Project: 1904 Bellamah Ave NW
DRB Project Number: PR-2022-007153 / SI-2023-01646 – SITE PLAN

Subject: DFT Resubmittal 2
Date: 01.19.2024

DRAWN BY	SB
DATE	11-16-22
DRAWING	
SHEET #	SP-1
JOB #	2022046

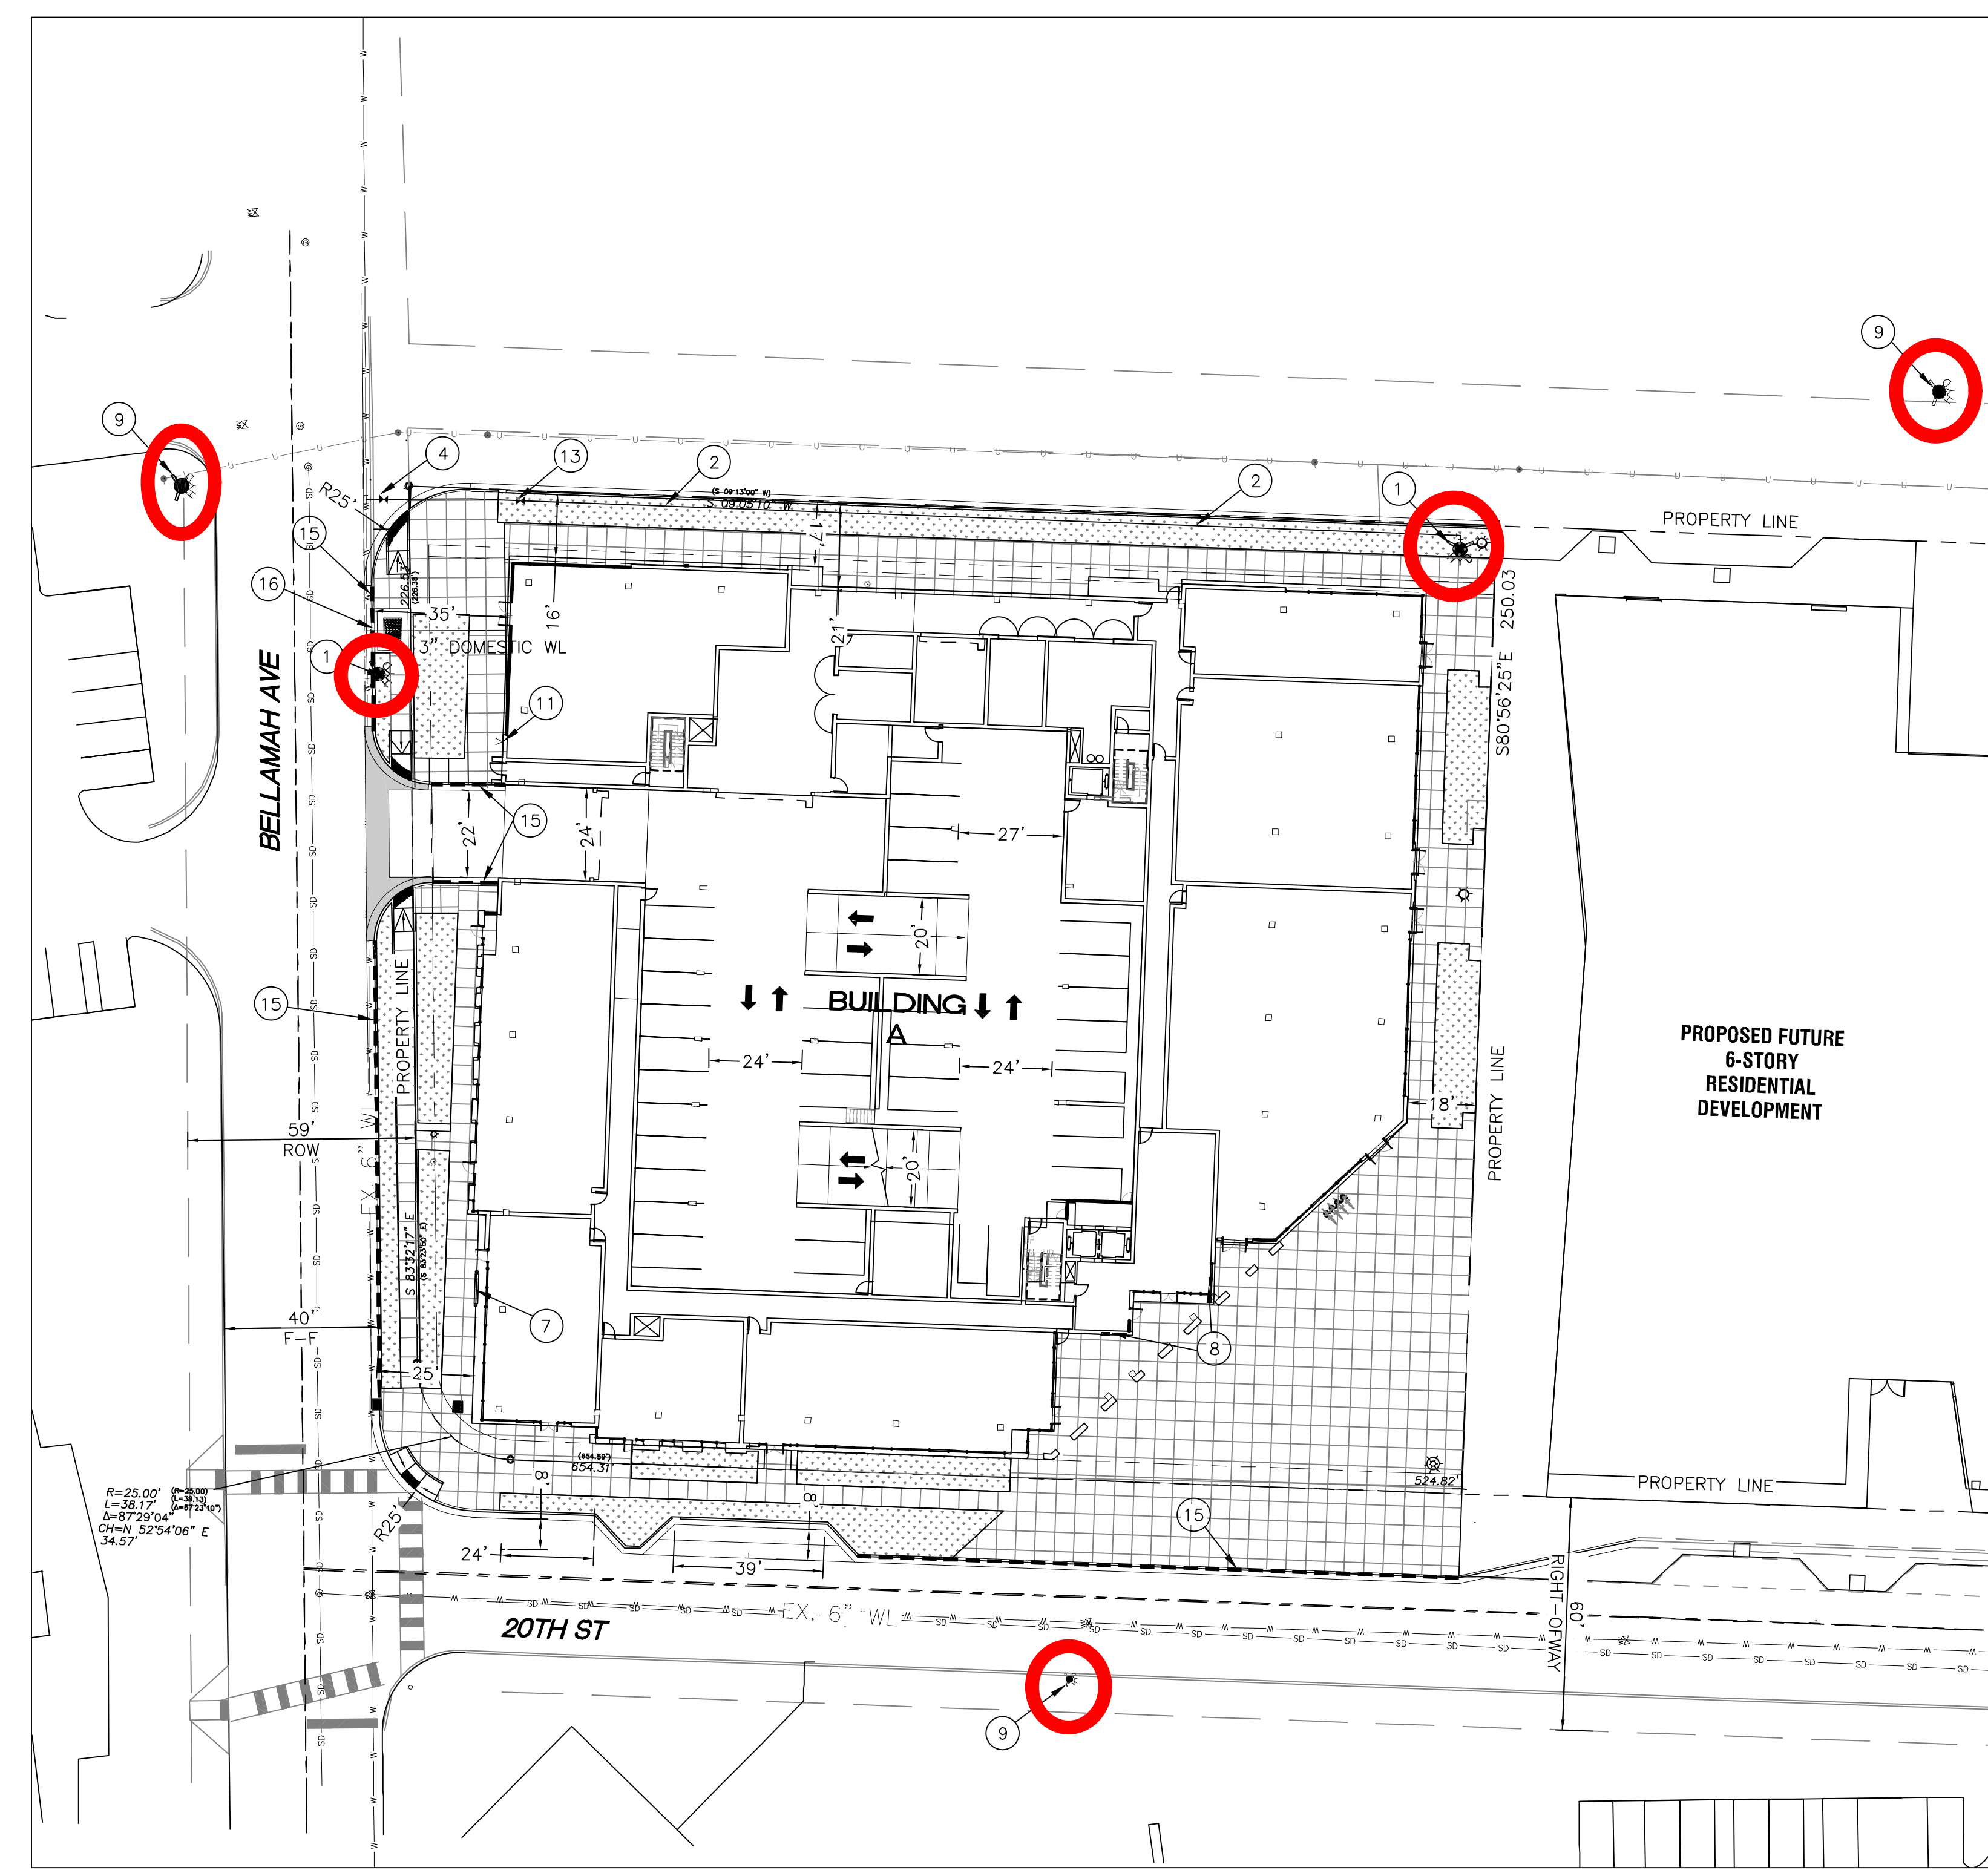
Contact Cross Connection at (505) 289-3465 for information on cross connection requirements.		
2	Connection Permit will require as-built coordinates on valves, meters and fire hydrants	This is an informational item to be completed with the Connection Permit	
3	Private Fire Hydrants shall be painted safety Orange.	This note was added to the Master Utility Plan	
4	Review easement requirement for 3" meter vault. Recorded easement is required.	The 3" meter pit was replaced with two 2" water meters placed in a standard double meter box and a ¾" meter in a standard single box. All boxes fit within the street right-of-way, so no easement is needed.	
5	Fire hydrant on Bellamah should be public.	The note was revised to state this fire hydrant is public.
